WEST SUSSEX COUNTY COUNCIL CONSULTATION

TO:	Arun District Council FAO: Simon Davis
FROM:	WSCC – Highways Authority
DATE:	21 st April 2026
LOCATION:	Land North of Summer Lane Pagham
SUBJECT:	P/31/26/OUT Outline application with some matters reserved, except access, for up to 130 No residential dwellings including means of access into the site (not internal roads). This application is a Departure from the Development and affects a Public Right of Way.
DATE OF SITE VISIT:	10 th April 2026
RECOMMENDATION:	No Objection

Proposed Site Access Arrangement (HTp/2606/01)

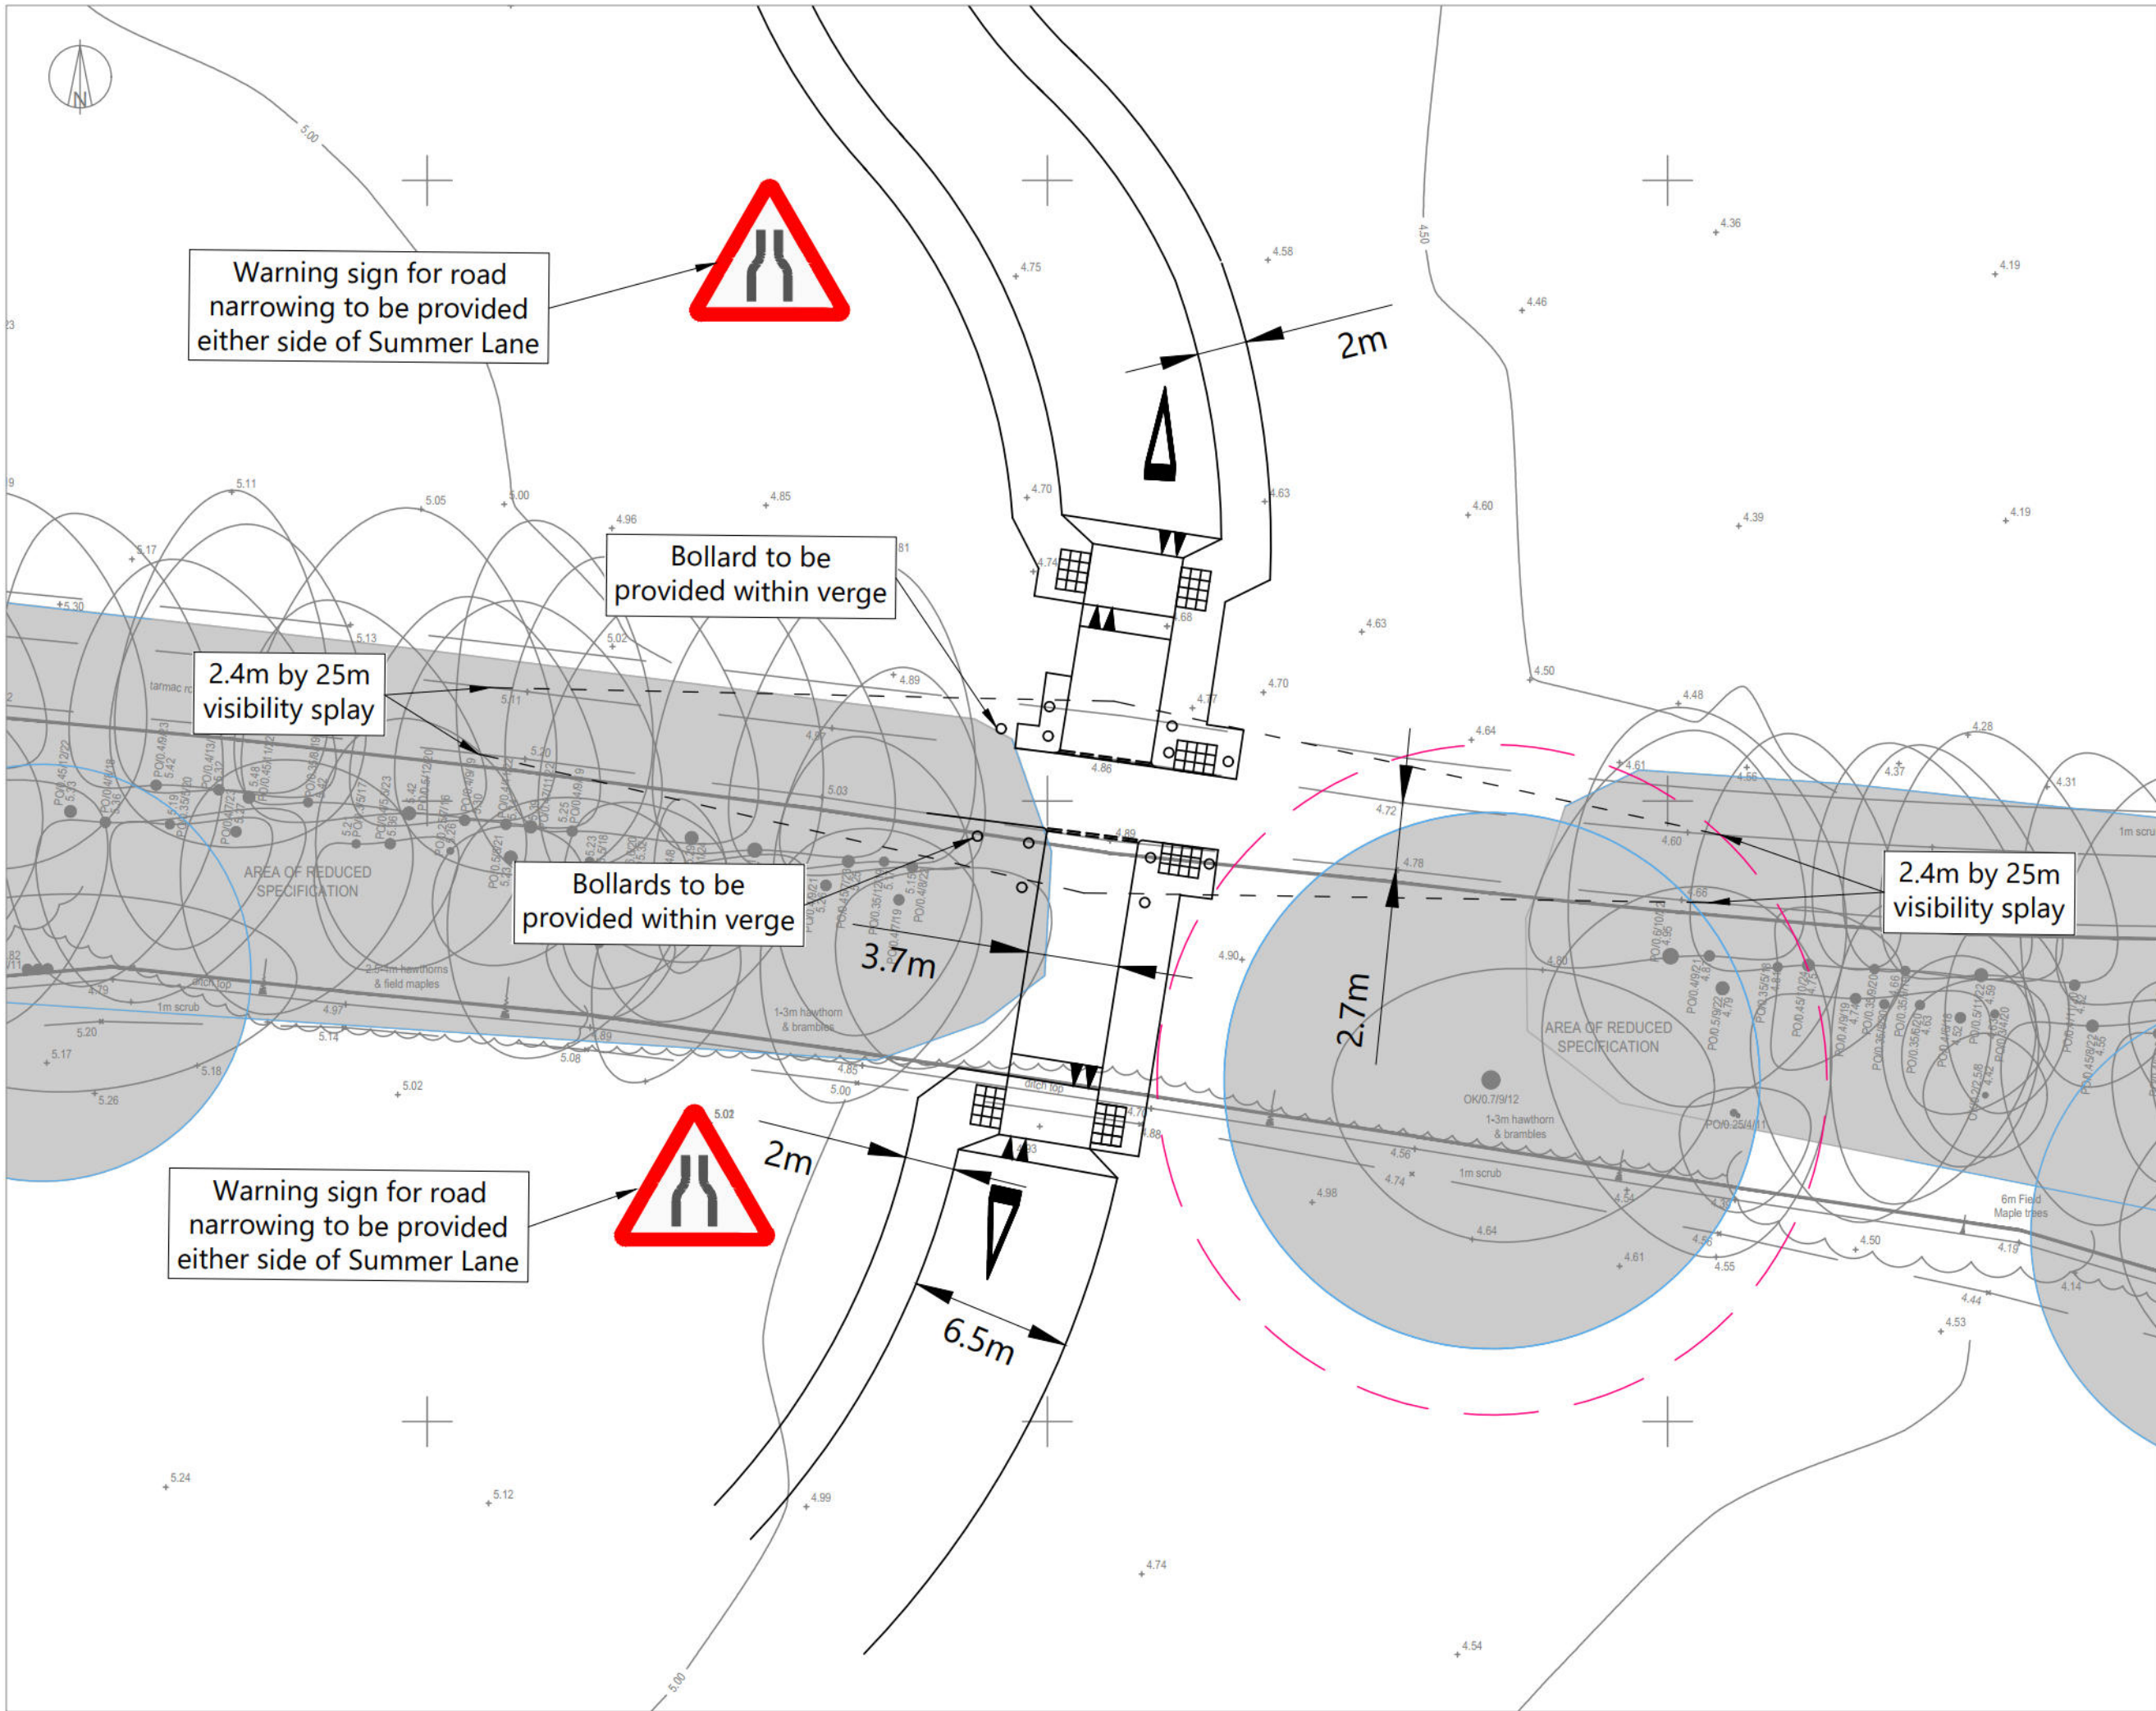
A carriageway of 6.5 metres narrowing to 3.7m, to reduce vehicular speeds and reduce crossing distance, with a raised table and tactile paving to promote safe use of the crossing. Drawing 01 shows visibility splays of 2.4 by 25 metres at the point of access, working on a 20-mph limit. The splays as shown are considered sufficient for the likely vehicles speeds. No forward visibility splays have been provided; however, the layout is considered acceptable to promote sufficient forward visibility for drivers, cyclists and pedestrians.

Drawing 01 shows to the south of Summer Lane, a 2.0-metre-wide footway is shown on the western side of the carriageway, crossing to the eastern side and continuing across Summer Lane to the northern side of the access road. In principle, the LHA would be satisfied with the arrangements as demonstrated.

Swept Path Analysis of Car Unable to Turn onto Summer Lane

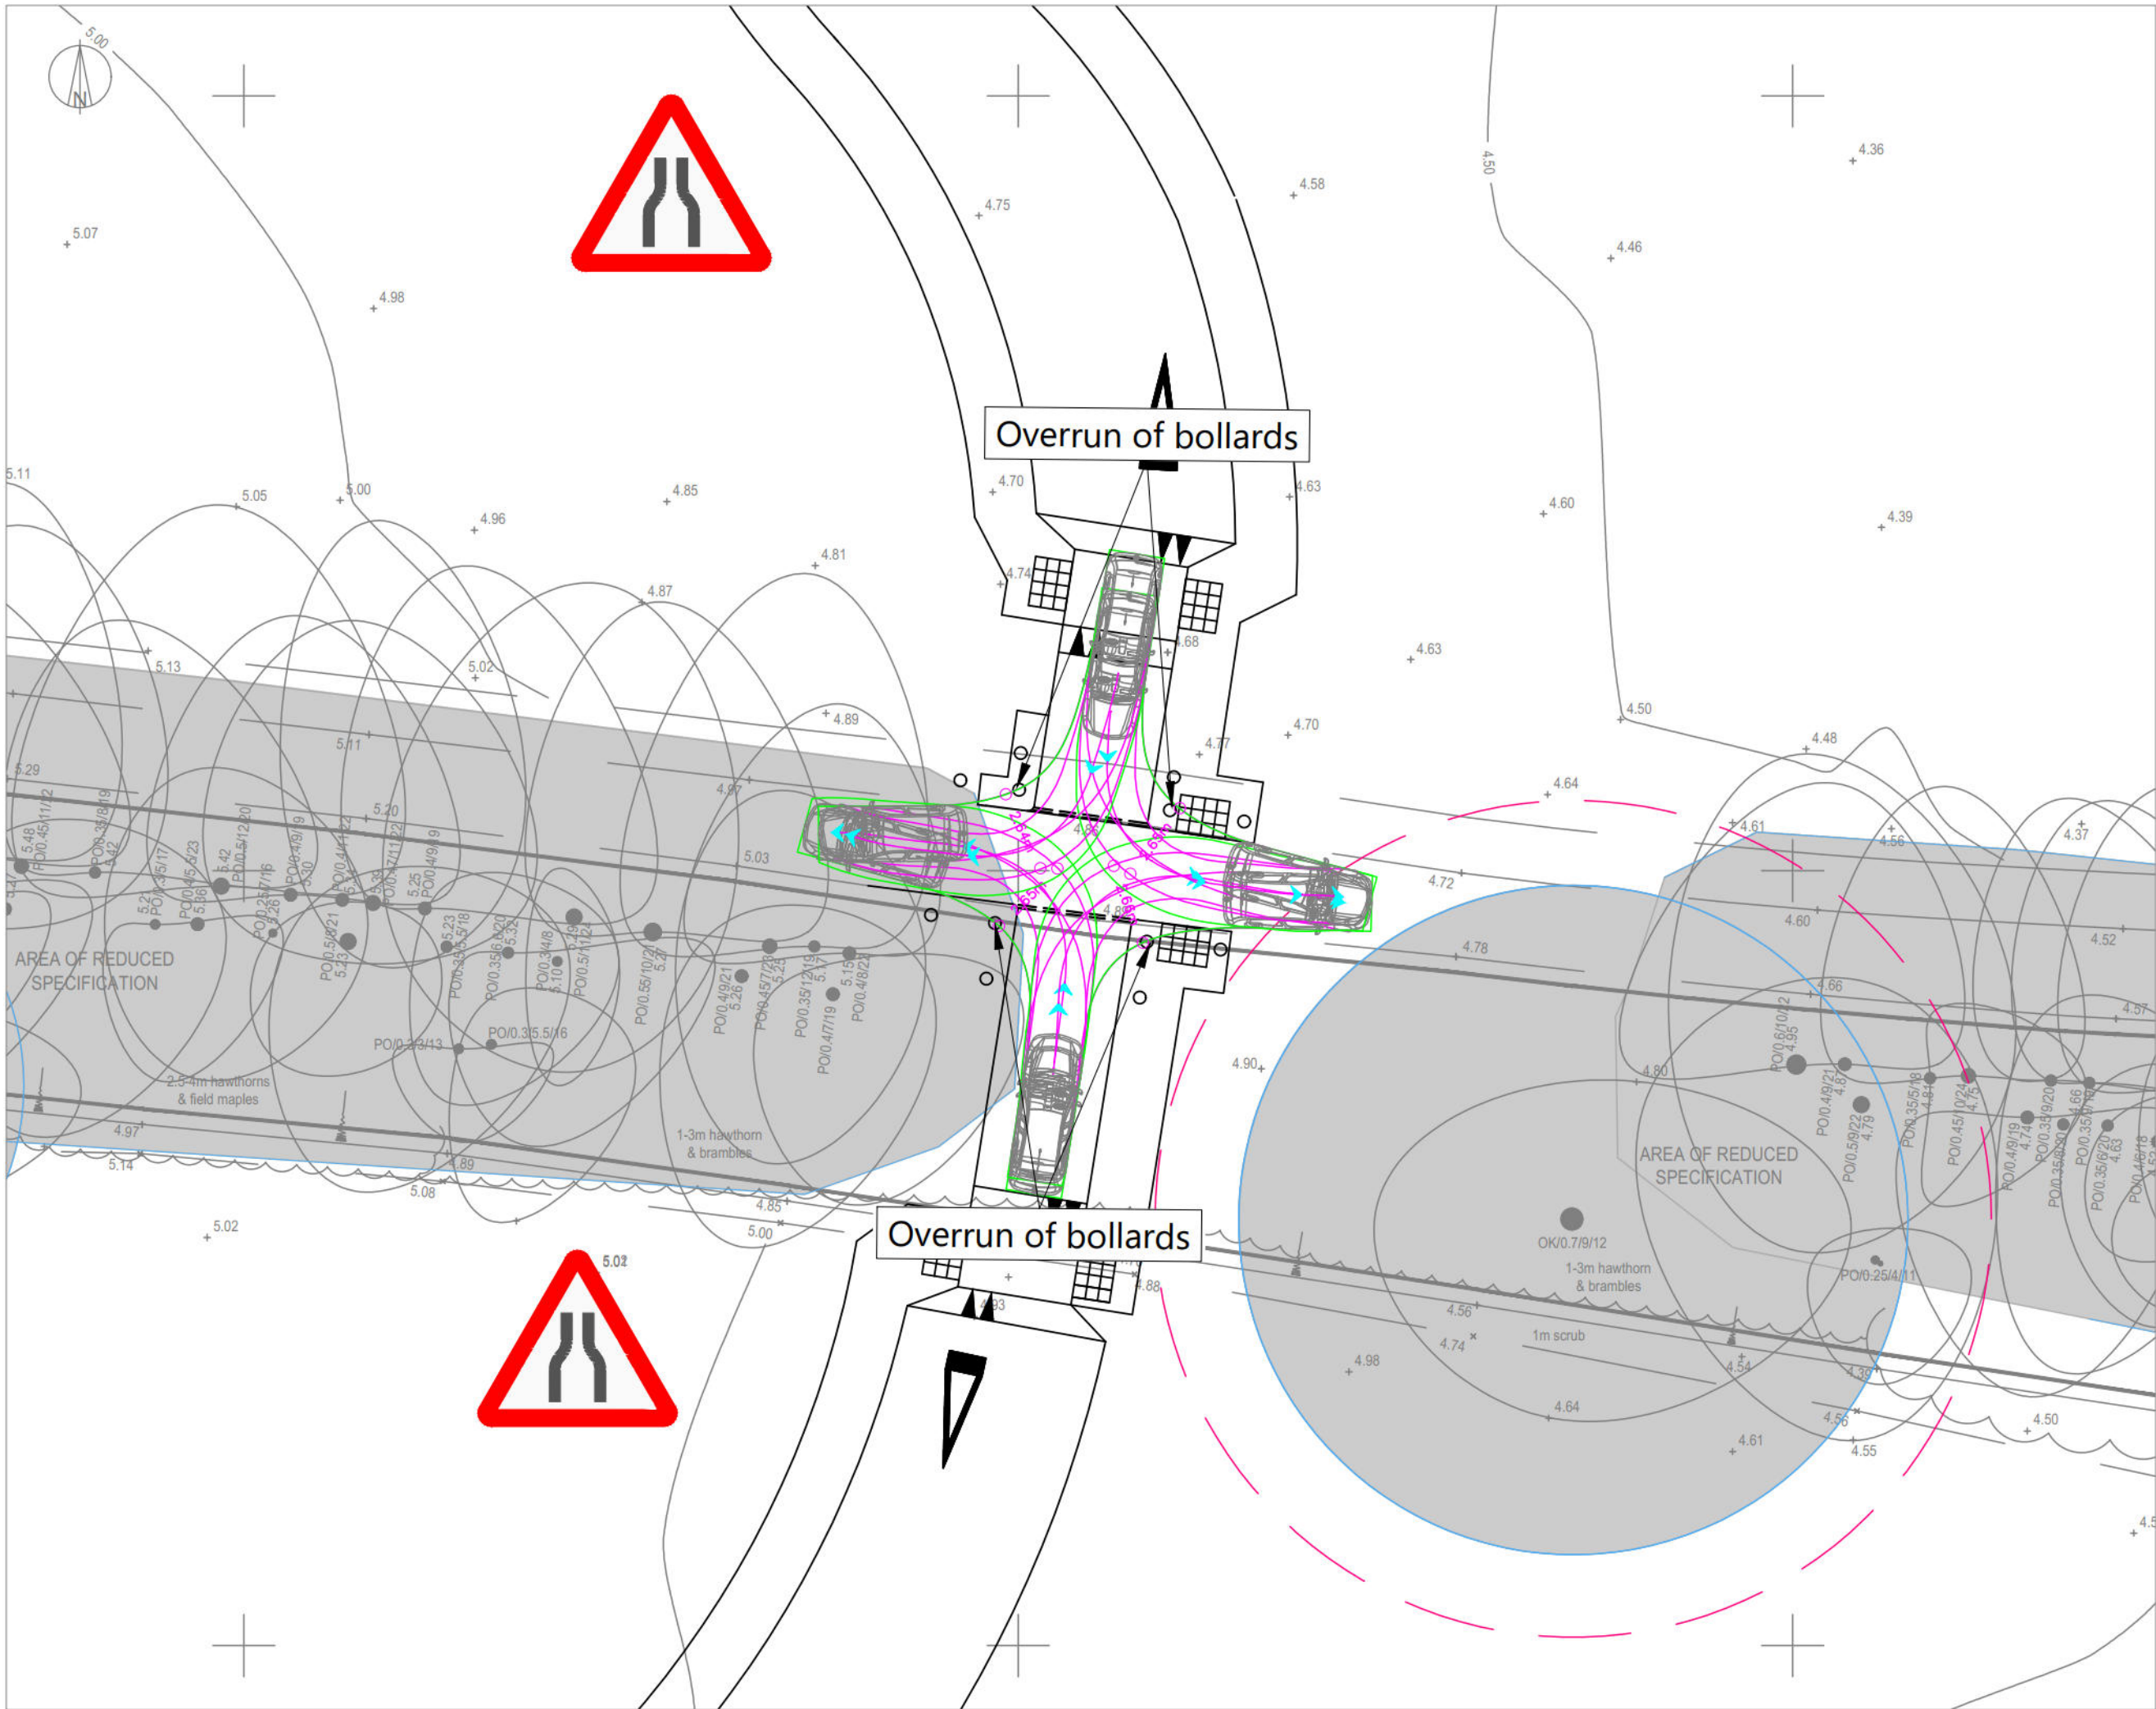
The access through to the approved scheme, south, has been designed to ensure that vehicles are unable to turn onto Summer Lane, nor will vehicles be able to turn from Summer Lane into the northern or southern parcels, only north/south vehicular movements will be able to occur to access the application site or P/15/24/OUT. Swept path analysis of a car at the junction unable to turn onto Summer Lane from the north and south is shown on drawing HTP/2606/TR/06, contained in Appendix 8 of the TA. The access

includes raised tables either side of Summer Lane to control speeds and alert drivers to the junction arrangement.
